# DRB CASE ACTION LOG

DRB Application No.: 02-01804 Project # 1002365  
 Project Name: \_\_\_\_\_ EPC Application No.: \_\_\_\_\_  
 Agent: Harry J. Anderson Phone No.: 899-8056

**Subject:            Joseph W. Von Cleave Homestead Addition**

15. **Project # 1002365**  
02DRB-01804 Minor-Prelim&Final Plat  
Approval
- HARRIS SURVEYING INC. agent(s) for ALBERT J. ADAMSKO and EDWARD N. VILLELLA request(s) the above action(s) for all or a portion of Lot(s) 15A & 16A, **JOSEPH W. VON CLEAVE HOMESTEAD ADDITION**, zoned C-3, located on GENERAL HODGES SE, between SUSAN SE and TRUMBULL SE containing approximately 1 acre(s). [REF: ZA-00-192] (L-20) **PRELIMINARY PLAT WAS APPROVED WITH FINAL PLAT SIGN OFF DELEGATED TO TRANSPORTATION DEVELOPMENT.**

PLAT OF LOTS 15-A AND 16-A, BLOCK 5 JOSEPH W. VAN CLEAVE HOMESTEAD ADDITION

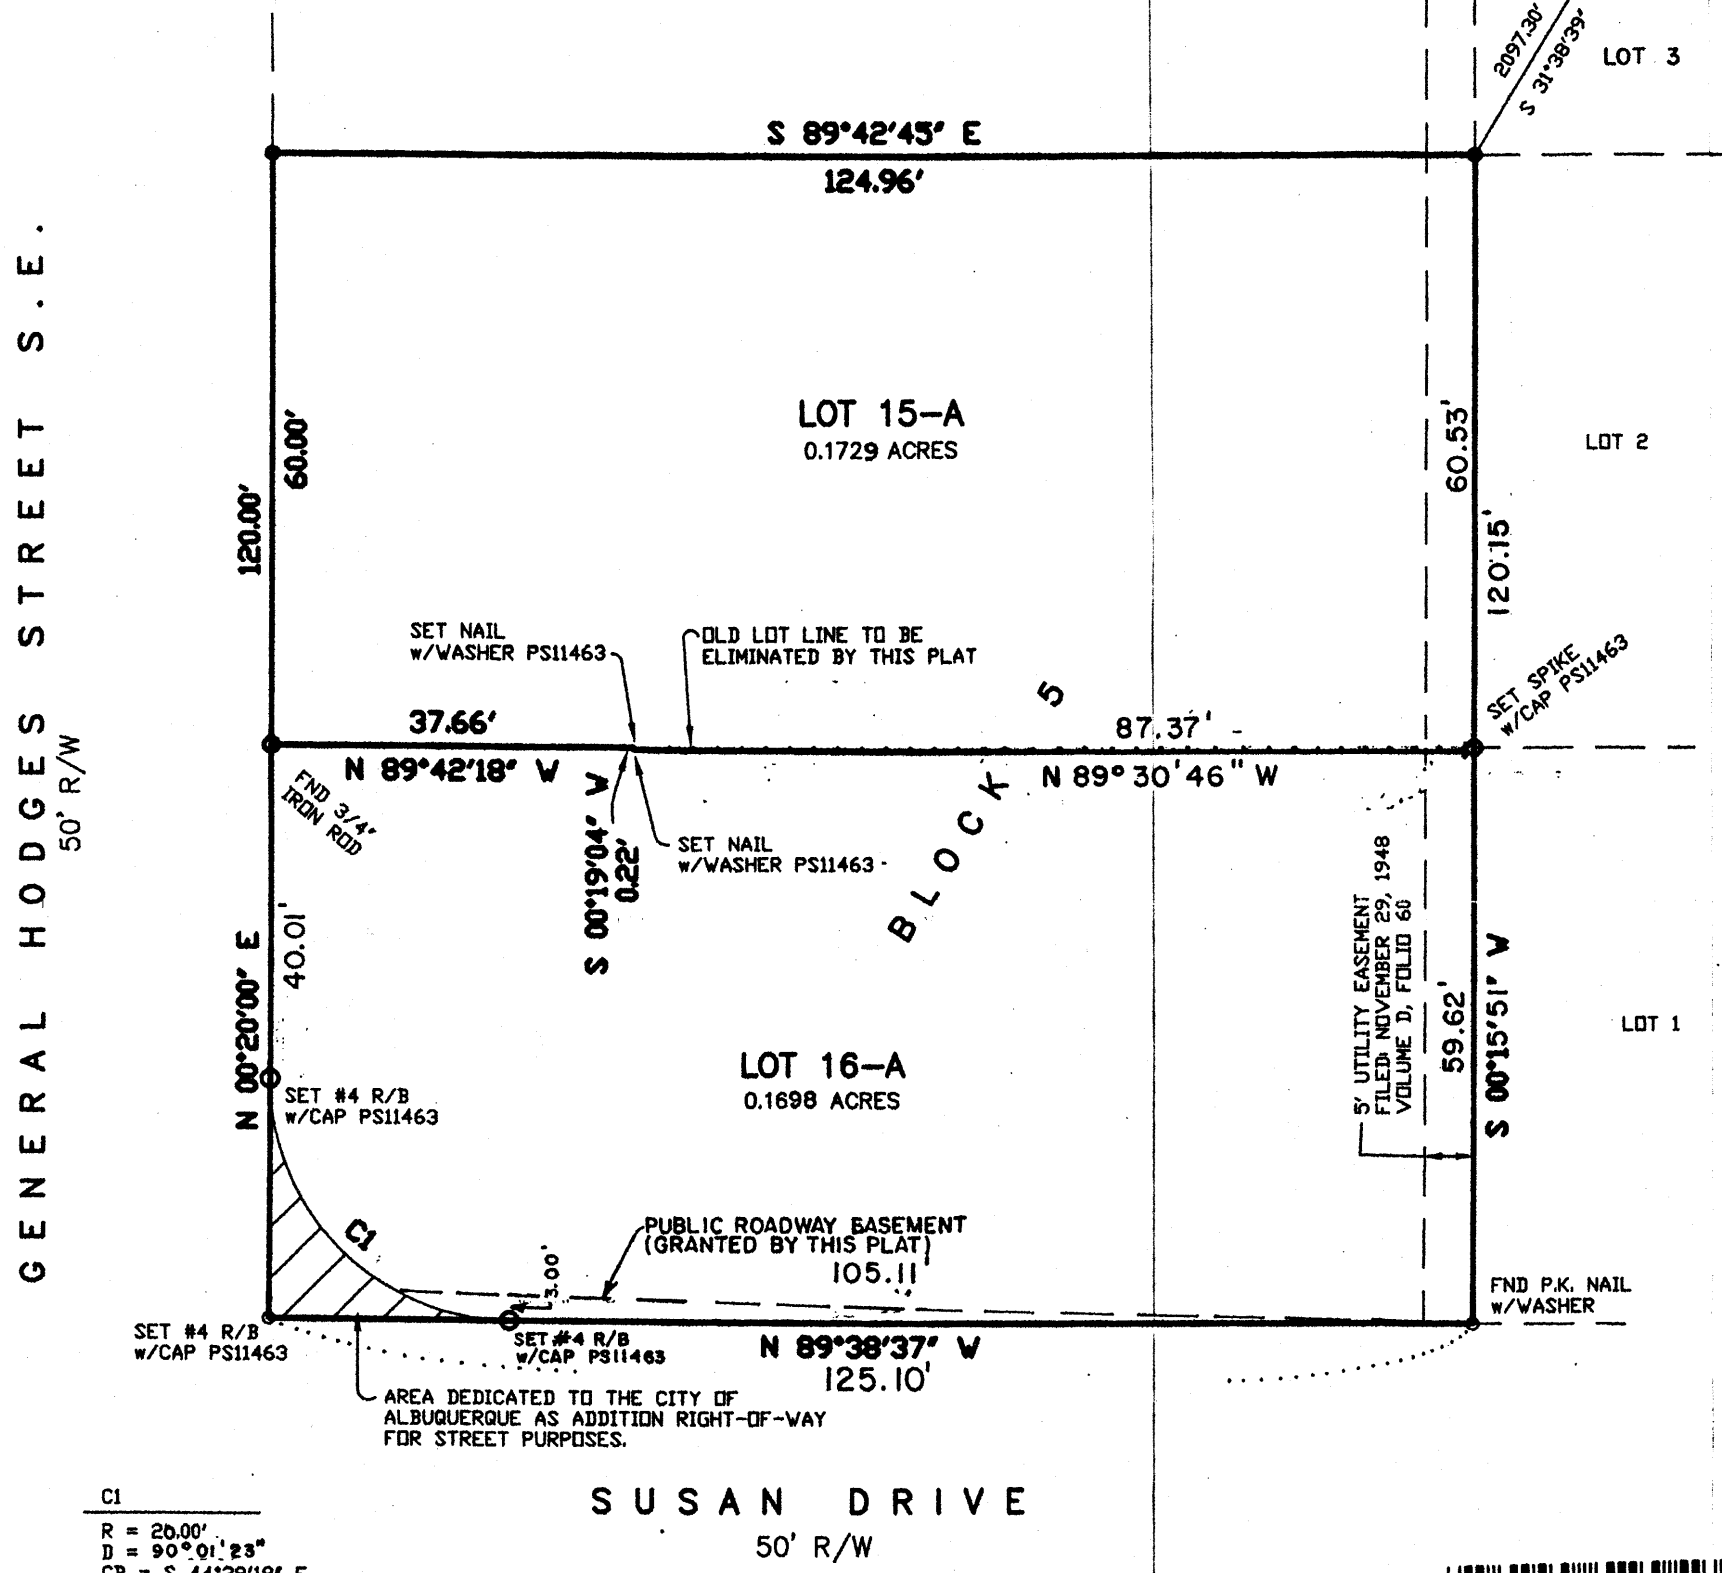
- TRANSPORTATION: - Address the clear sight requirements on Susan street.
  - \_\_\_\_\_
  - \_\_\_\_\_
  - \_\_\_\_\_
  - \_\_\_\_\_
- UTILITIES: \_\_\_\_\_

No.	Comment
<input type="checkbox"/>	Is curb, gutter and sidewalk along the perimeter? What is the distance from curb to property line?
